# CITY OF ALBUQUERQUE

September 6, 2021

**Re: US Eagle Credit Union - Academy**  
**5420 Academy Road NE**  
**Traffic Circulation Layout**  
Engineer's Stamp 09-03-2021 (E18-D046)

Sheet No. **C-101**

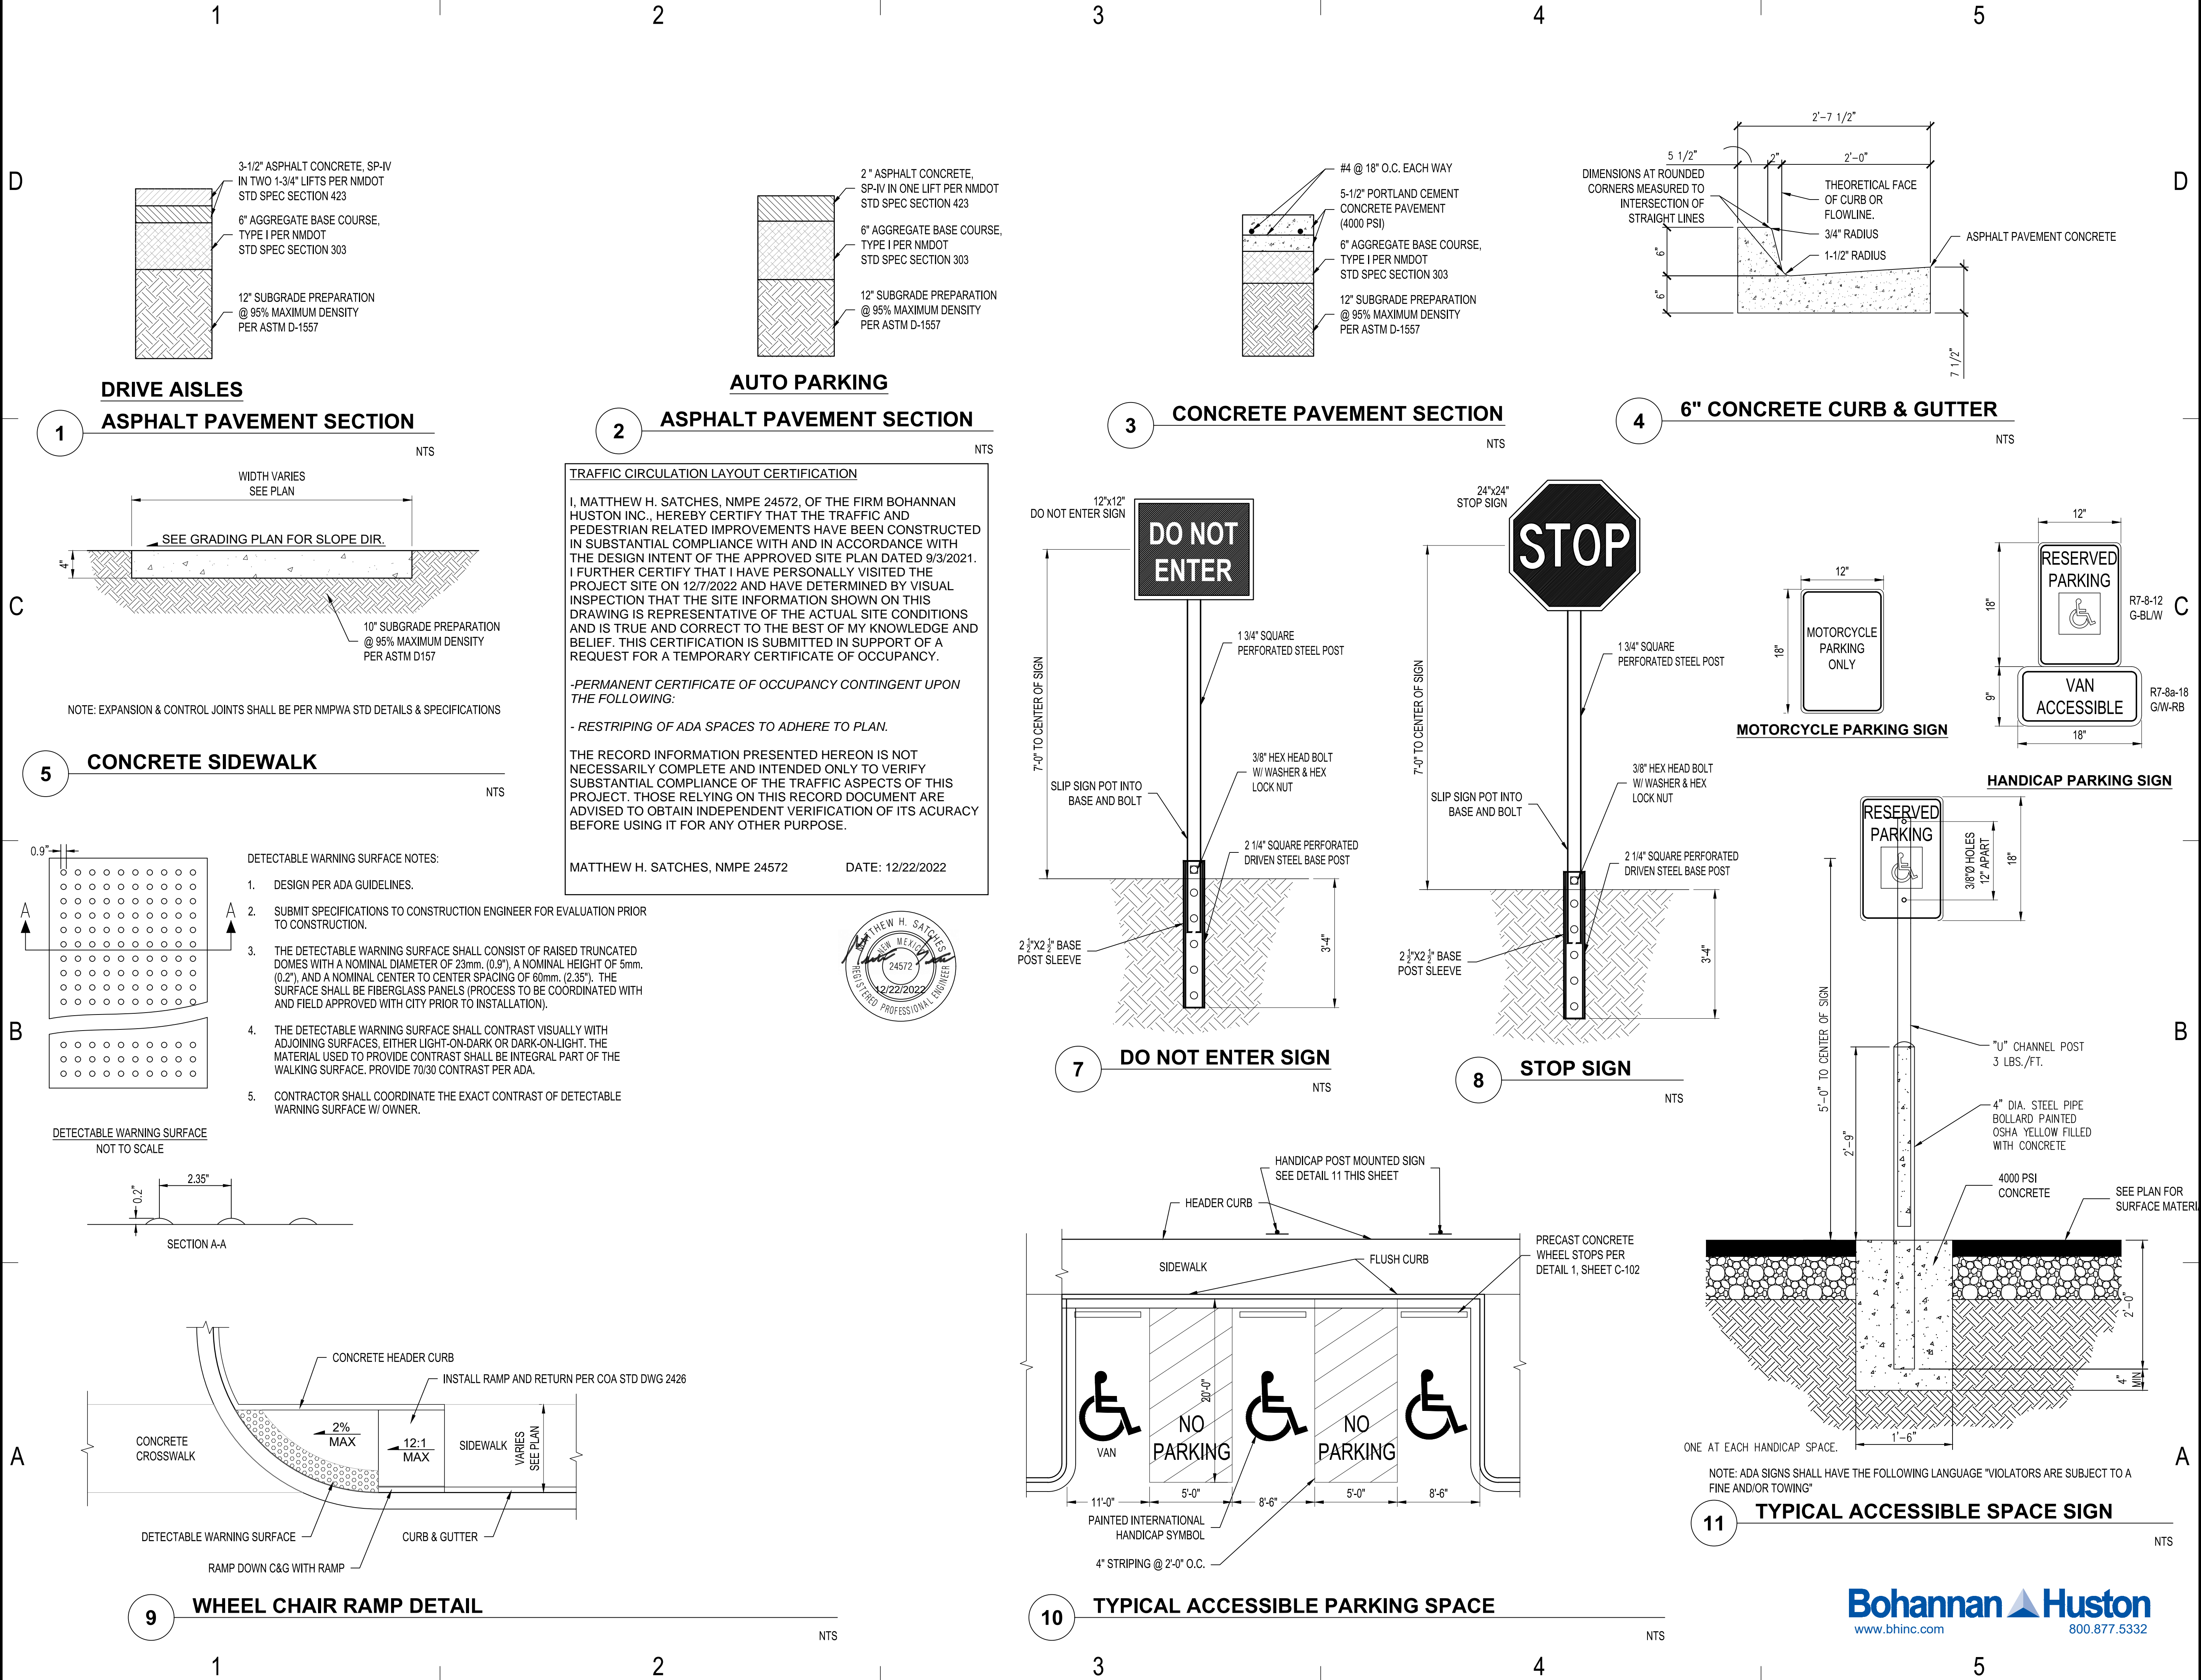
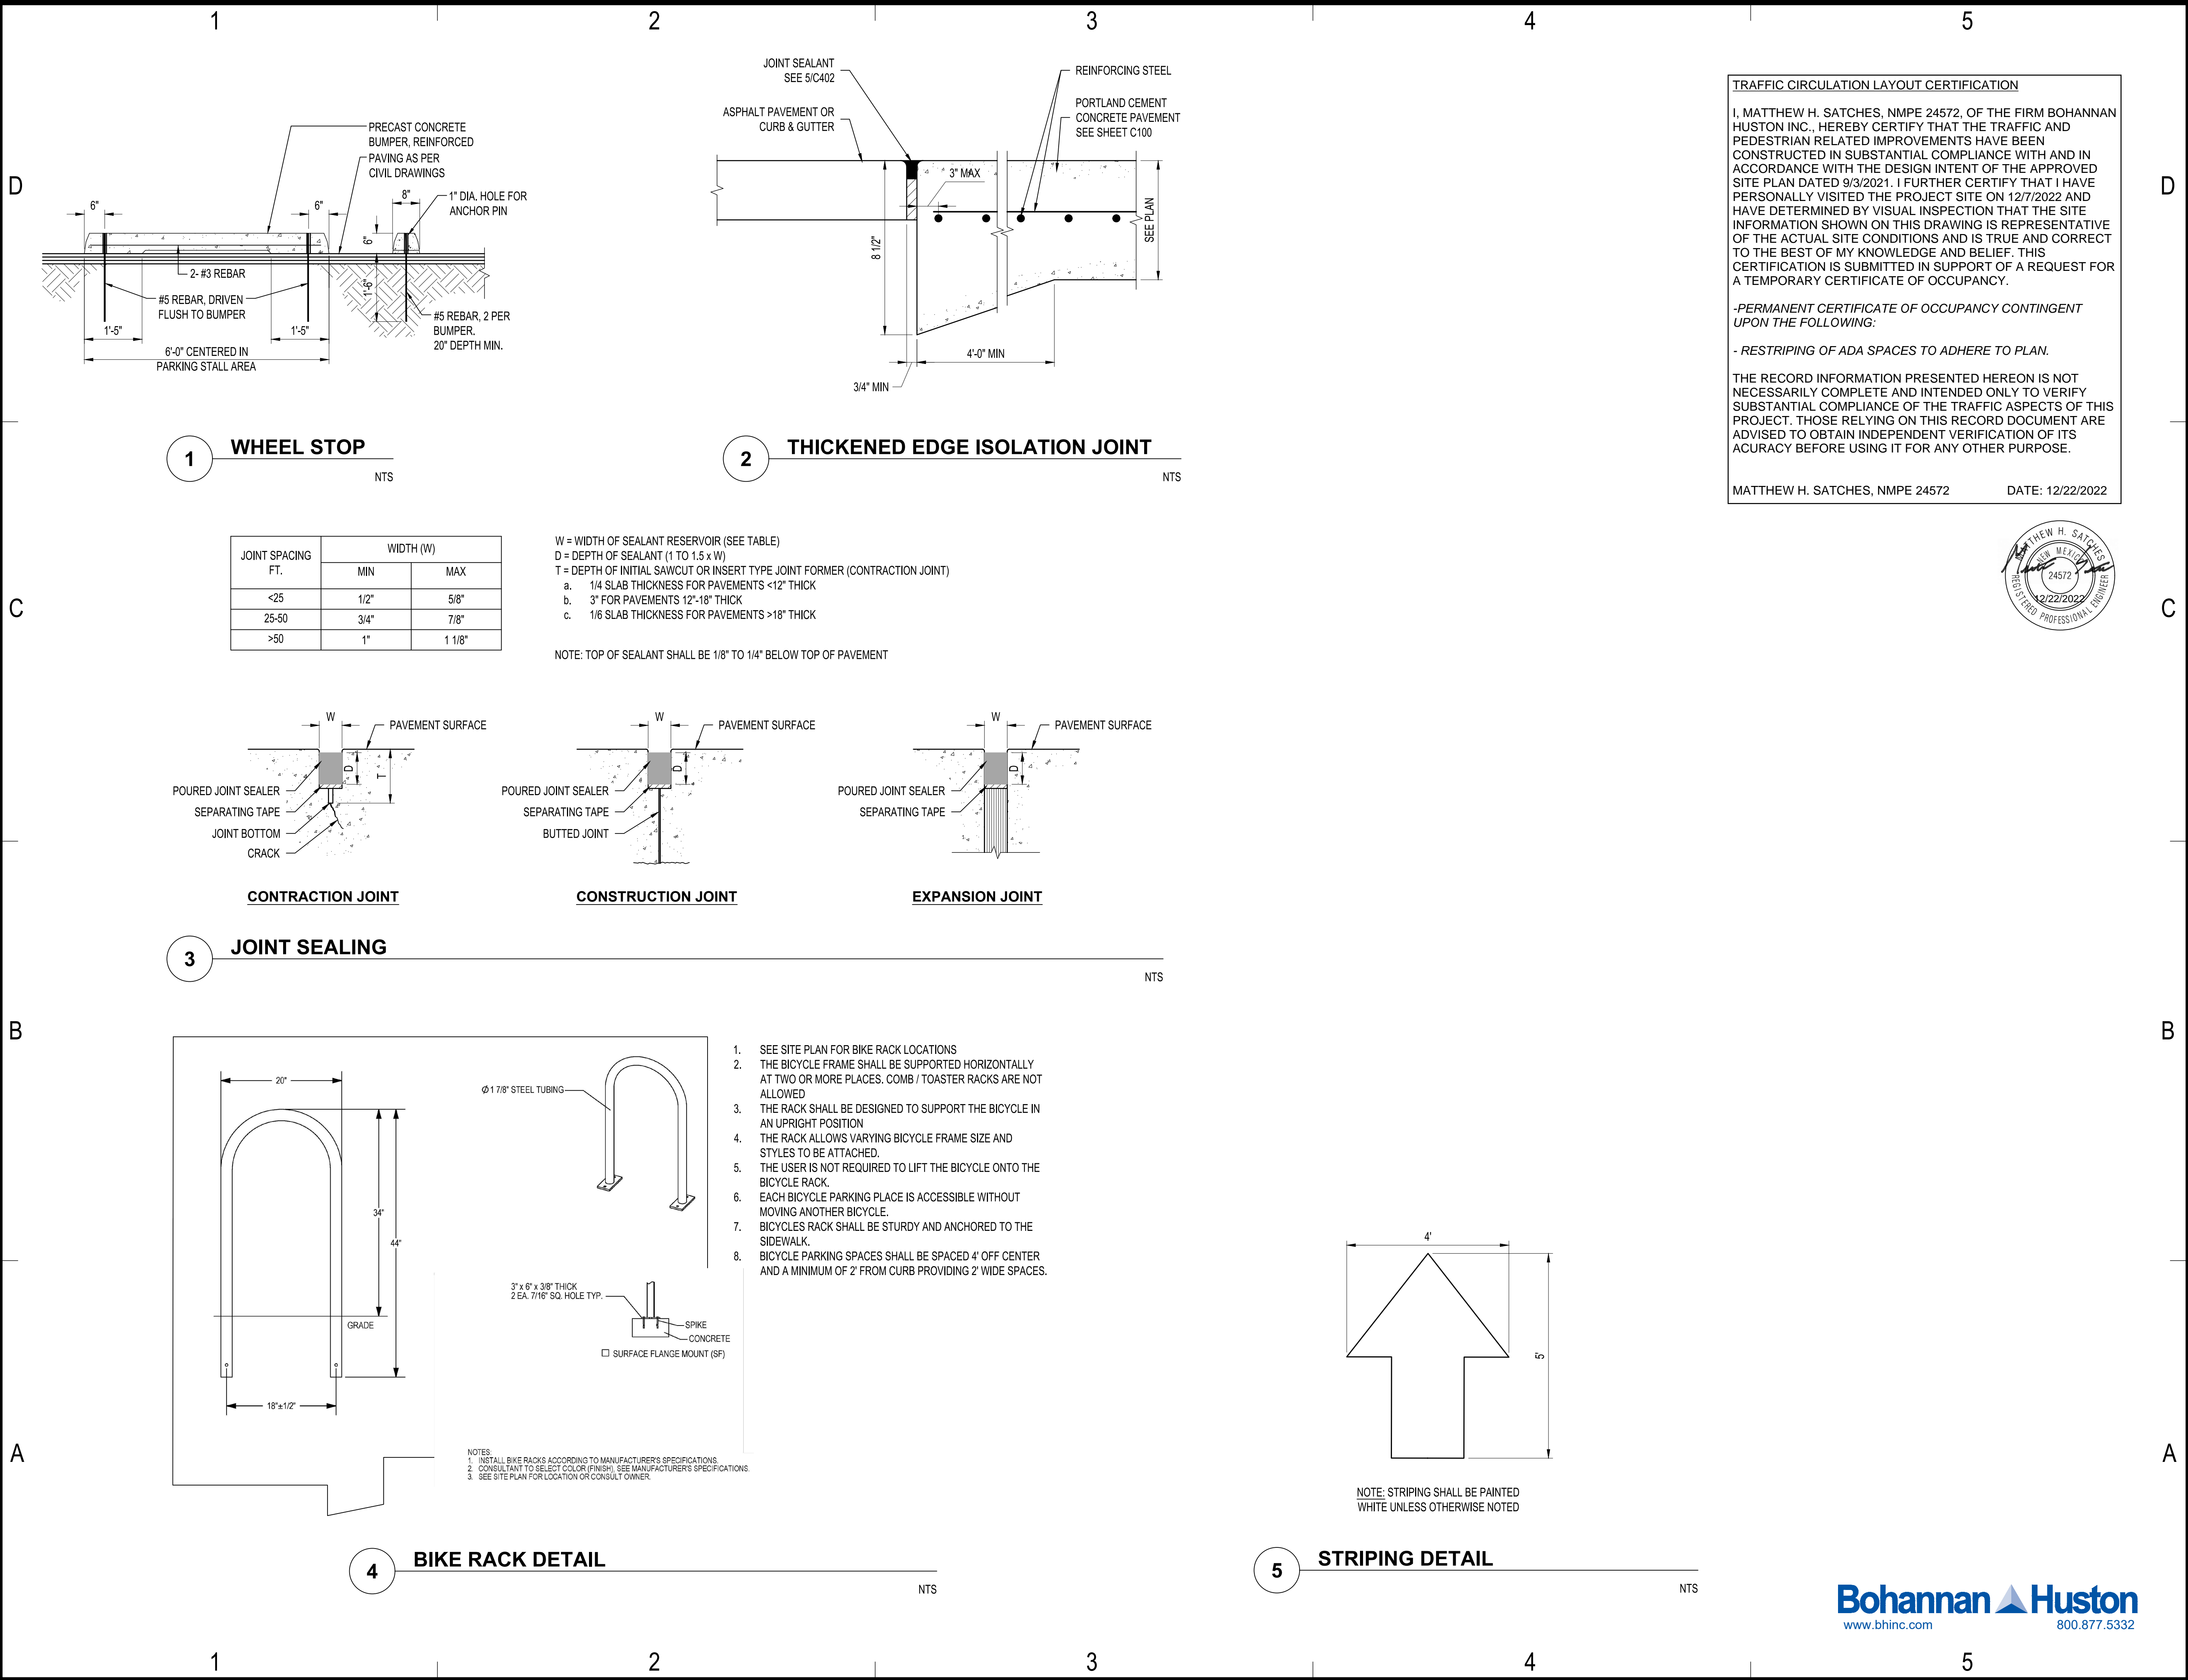
4. Proposed driveways off Academy and Seagull will need construction notes for private entrances. **Suggest COA std dwg 2426.**
5. **Keyed Note 1 (Detail 4/C-101):** You call out 6" c&G but you show 8" on detail dimension. Please adjust detail.

6. **Keyed Note 2:** Provide the proposed sidewalk width coming off Seagull.
7. **Keyed Note 3 (Detail 9 Sheet C-101):** Add/reference COA std dwg 2426 or 2446.

4 BIKE RACK DETAIL

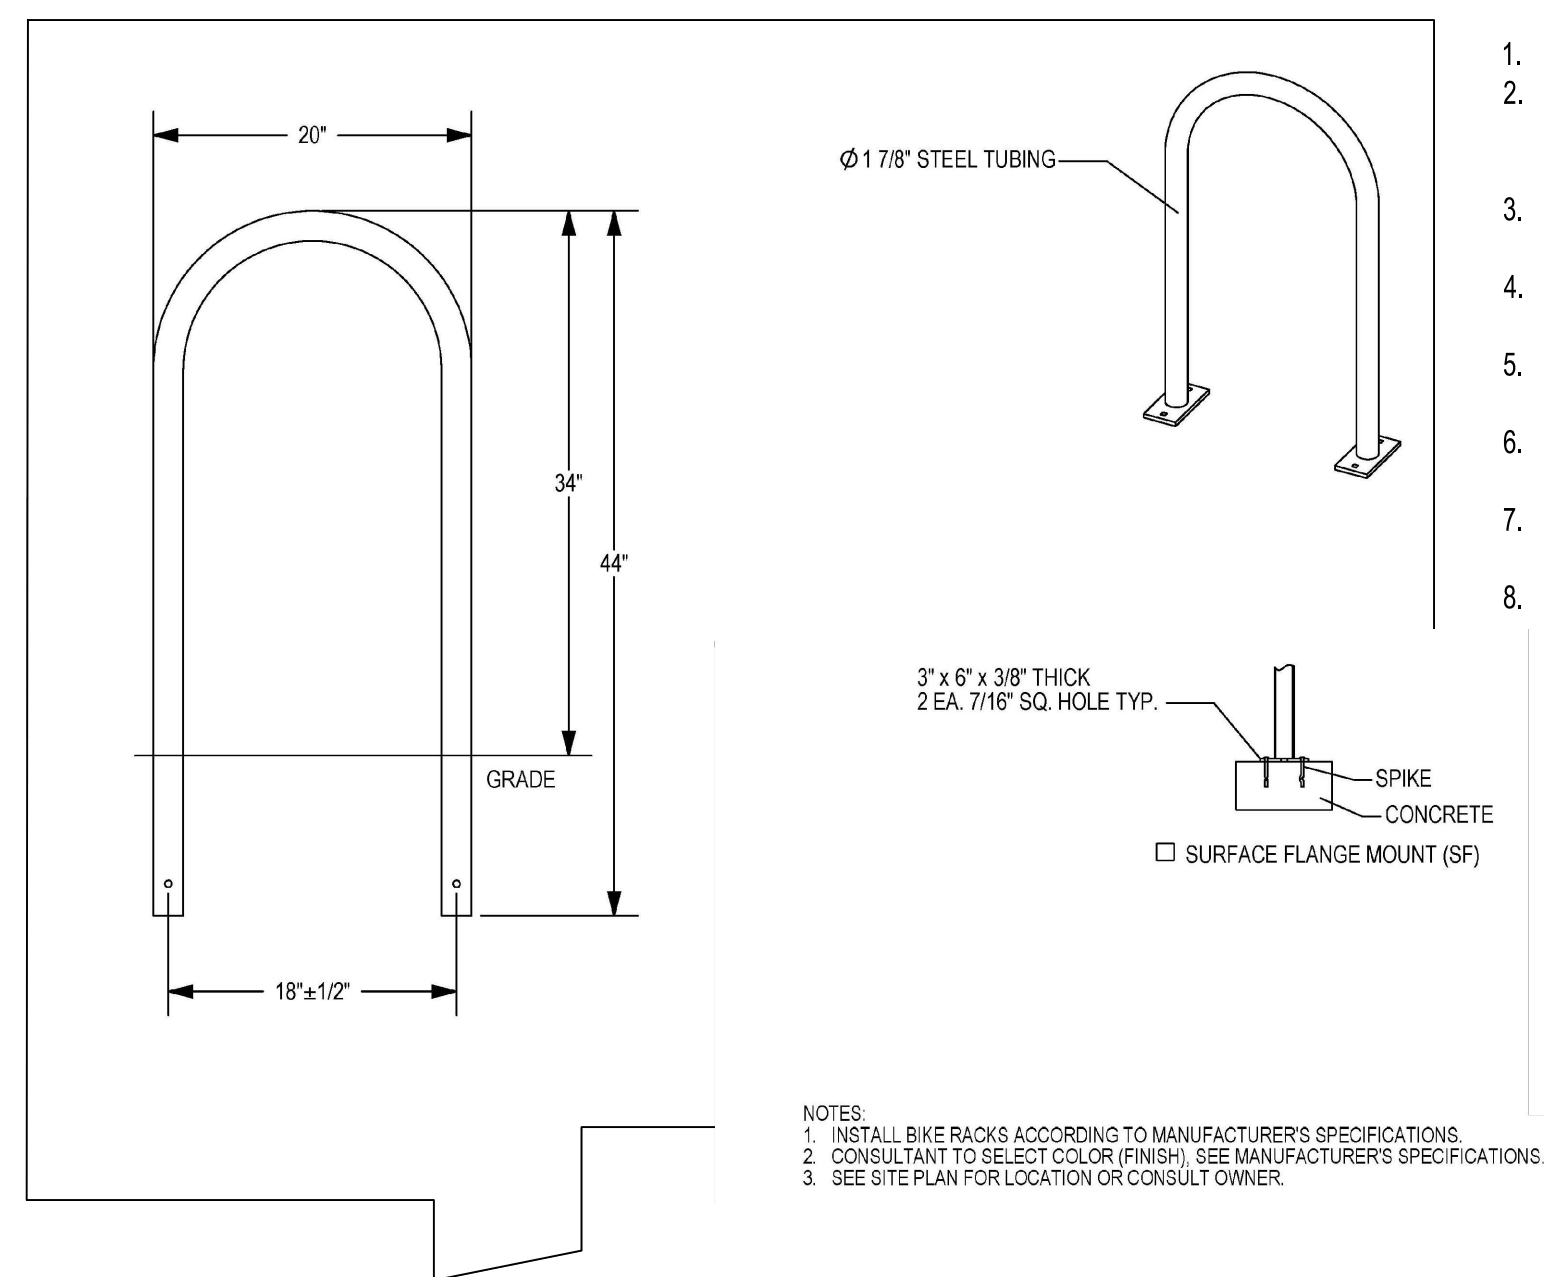
Proposed Bicycle Infrastructure (**Proposed detail on sheet C-102**) verify these details comply with proposed details below:

20. All bicycle racks shall be designed according to the following guidelines:
  - a. The rack shall be a minimum 30 inches tall and 18 inches wide.
  - b. The bicycle frame shall be supported horizontally at two or more places. Comb/toaster racks are not allowed.
  - c. The rack shall be designed to support the bicycle in an upright position. See the IDO for additional information.
  - d. The rack allows varying bicycle frame sizes and styles to be attached.
  - e. The user is not required to lift the bicycle onto the bicycle rack.
  - f. Each bicycle parking space is accessible without moving another bicycle.
21. Bicycle racks shall be sturdy and anchored to a concrete pad.
22. A 1-foot clear zone around the bicycle parking stall shall be provided.
